# M5 Junction 10 Improvements Scheme

Change Log for Volume 2 Plans

TR010063 - APP 9.46

#### Volume 2 Plans Schedule of Change

Project Title <b>M5 Junction 10 Improvements Scheme</b>							
Drawing Title <b>GENERAL ARRANGEMENT PLANS REGULATION 5(2)(o) SHEET 12 OF 16</b>							
Drawing Number <b>TR010063/APP/2.9</b>							
Original Scale: A1	Scale: 1:1250	Project Ref. No: 5228847	Sheet: 12 of 16	Rev: C02

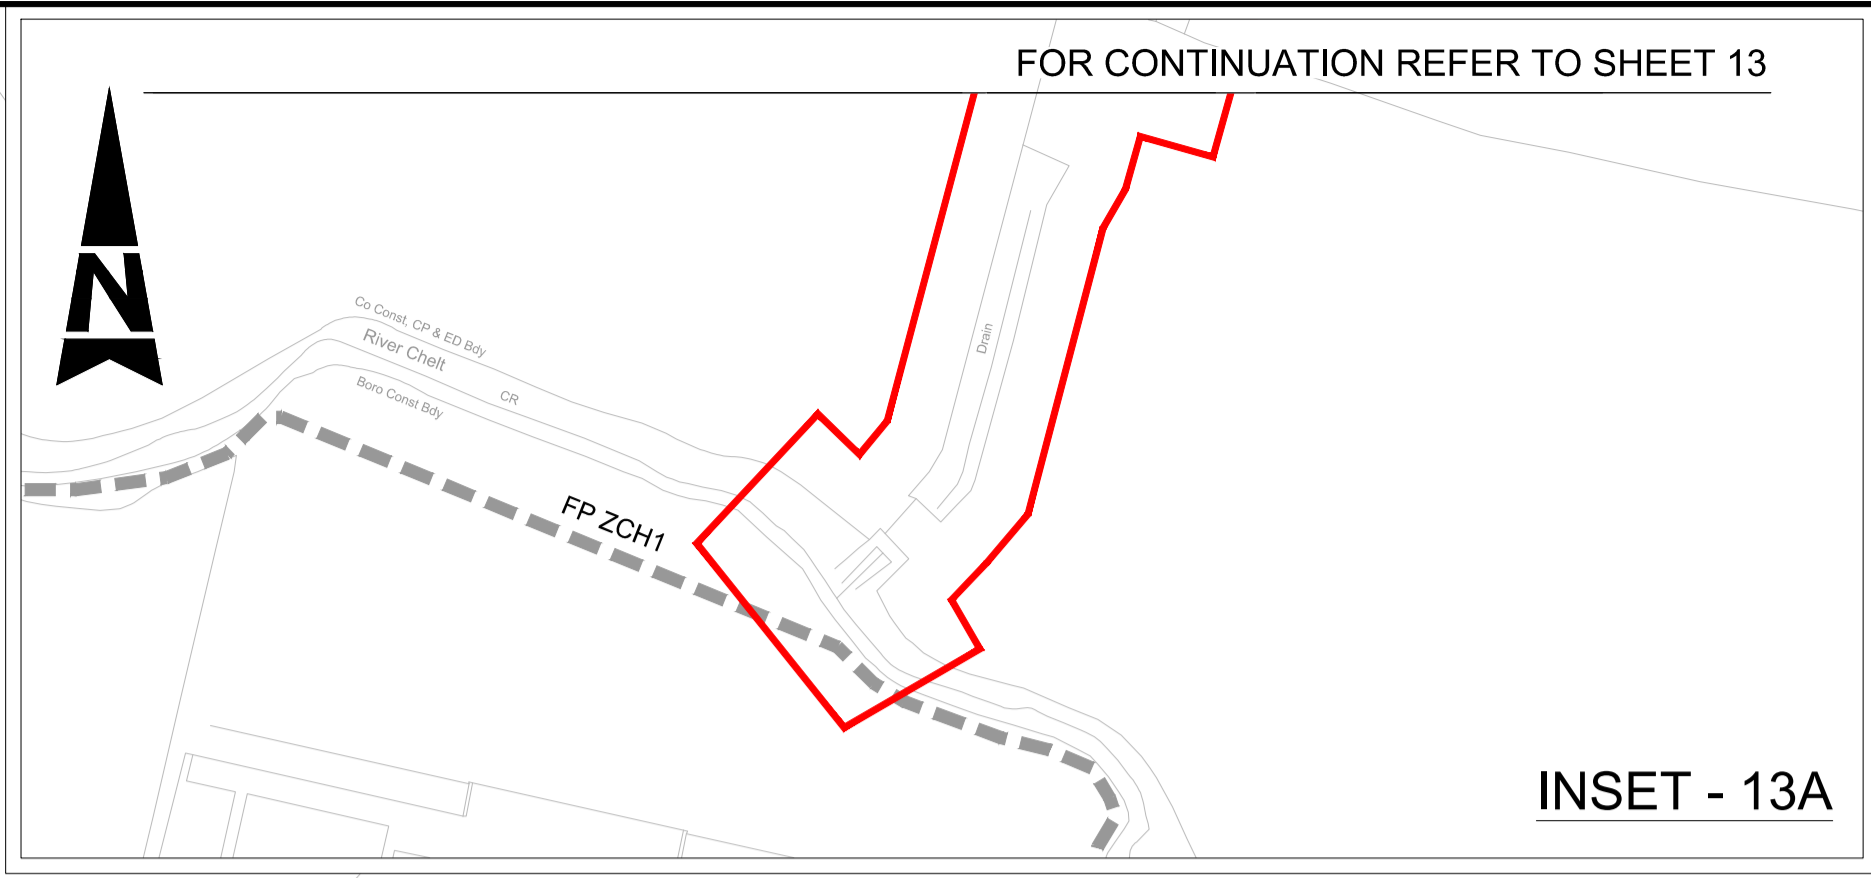
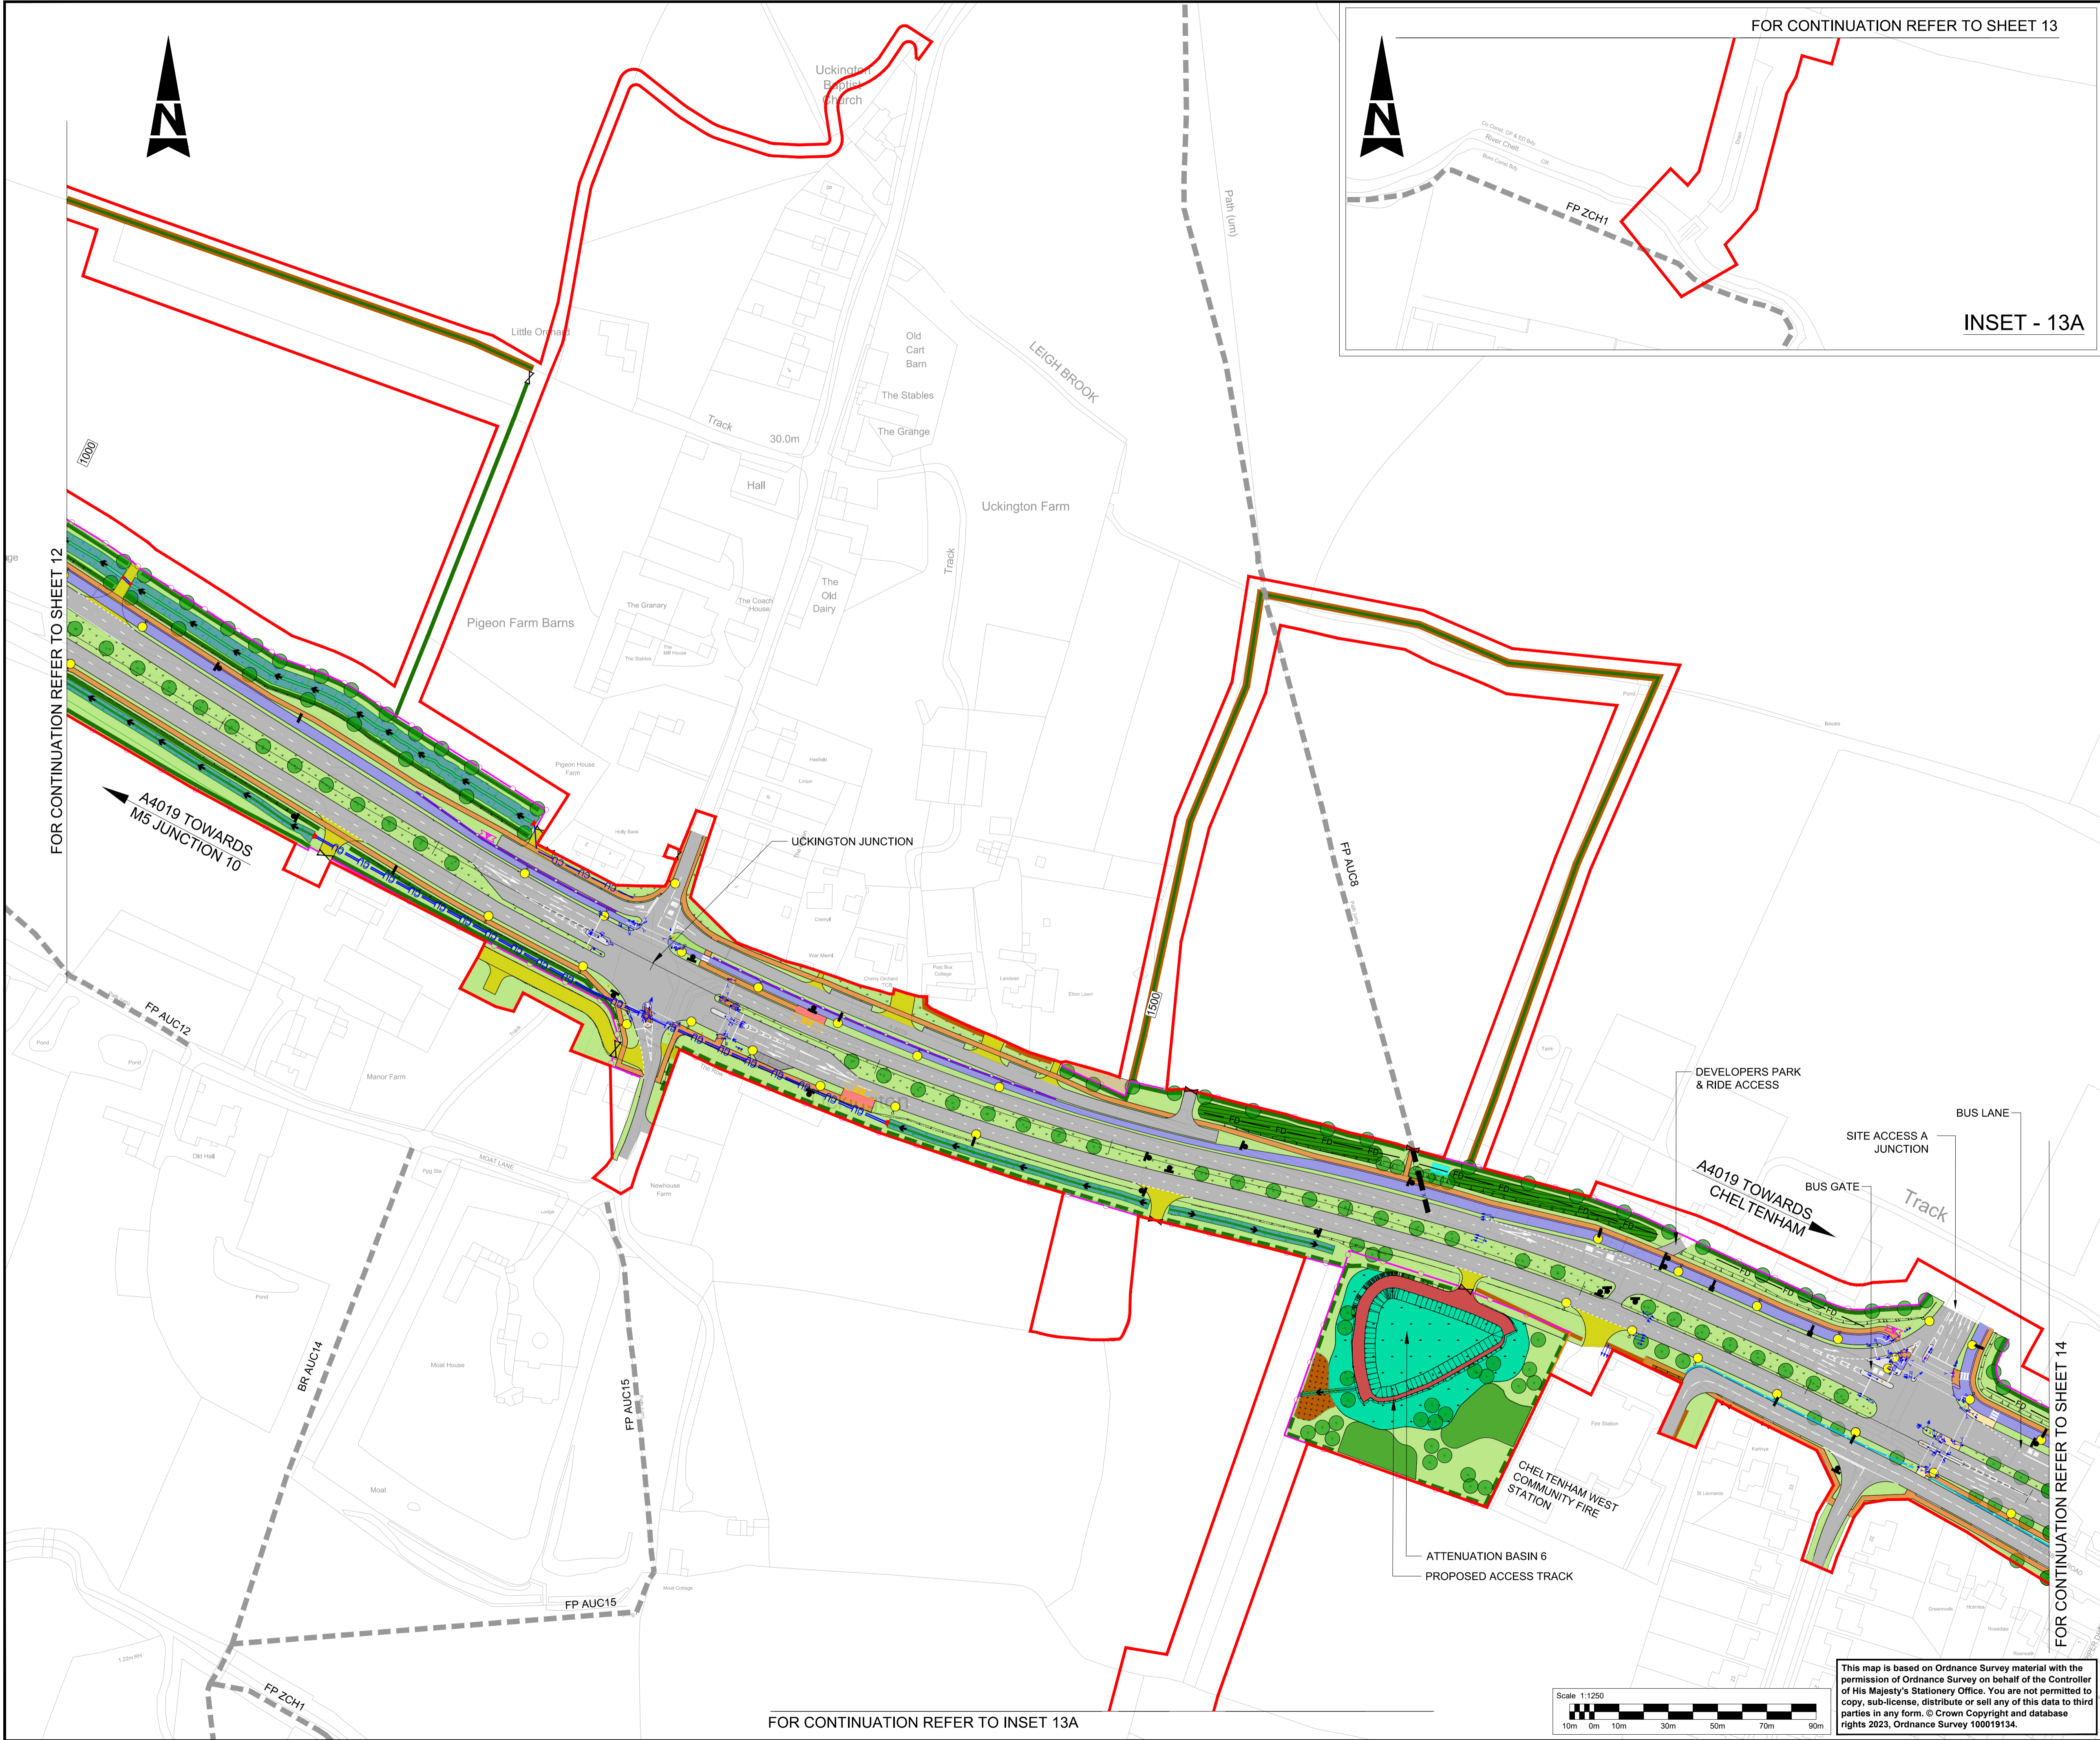
TR010063 – APP 2.9	General Arrangement Sheet 4 of 16	Area of proposed landscape work reduced at existing Barn Farm access track. This is linked with Works Plans Sheet 4 change i.e. reducing the area of Work No. 2b and increasing the area of Work No. 1j.
TR010063 – APP 2.9	General Arrangement Sheet 12 of 16	Creating a gap in the Work No. 4j 'mitigation planting for dormice' for access. Linked with Works Plans Sheet 12 and EMP Sheet 12 changes.

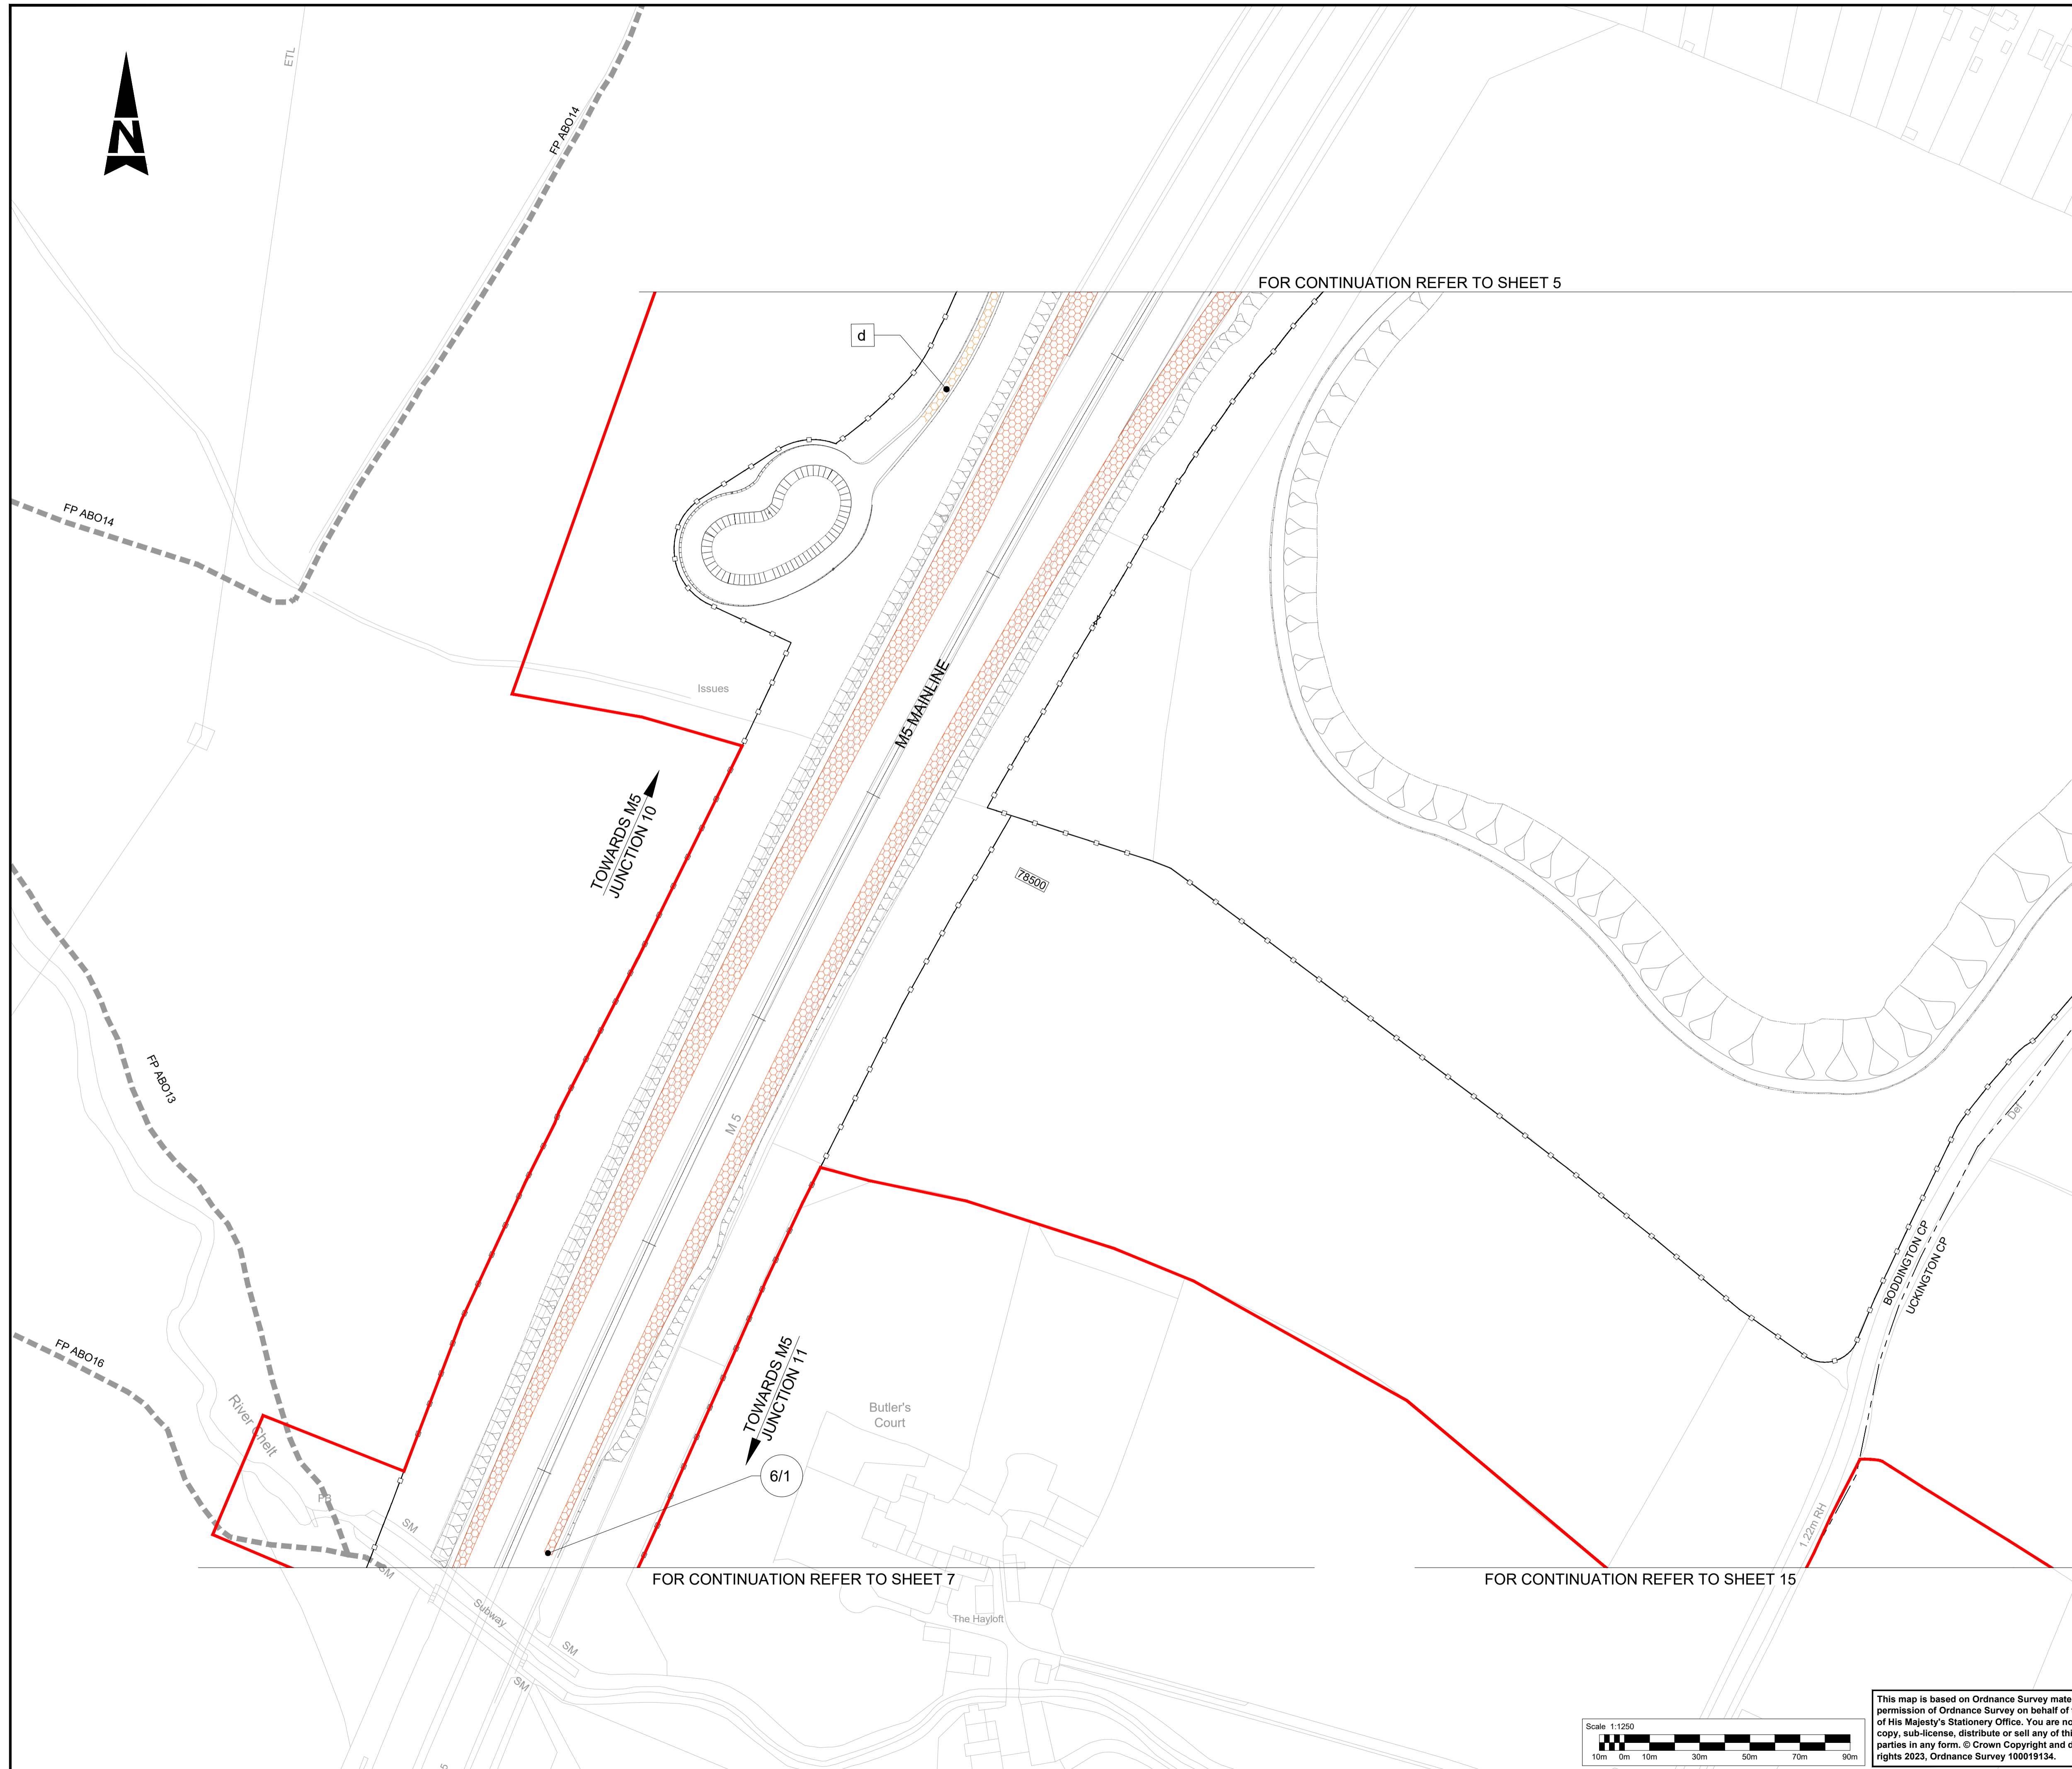
Document number	Drawing title	Description of change
		Addition of Traffic Signal Symbols at the proposed A4019/WCLR junction to address comment received from Joint Council (missing at this junction but included at other proposed signalised junctions).
TR010063 – APP 2.5	Streets, Rights of Way and Access Plans Sheet 5 of 12	<p>Updated to address PINS comment:-  <i>'In Part 1, Sheet 5 of 16 for the drawings (PDF page 11/17), seems to be an inset missing to show the stopping up of the old N/B onslip road under the junction overbridge as per the below:</i></p> <p><i>We'd suggest updating these drawings with the additional inset panel and submitting these to the ExA for the DCO process. I'm sure that whatever is happening at this location under the gyratory is referenced in the suite of DCO documentation - but for full transparency and to clearly show that, what we can assume, is that the existing slip is to be stopped up. '</i></p> <p>Rather than adding an additional inset to the drawing we have added a boundary line to the slip road so that the stopping up of the N/B onslip is clearly shown on the main plan.</p> <p>The stopping up of the overbridge is then shown fully on Inset-5A.</p>
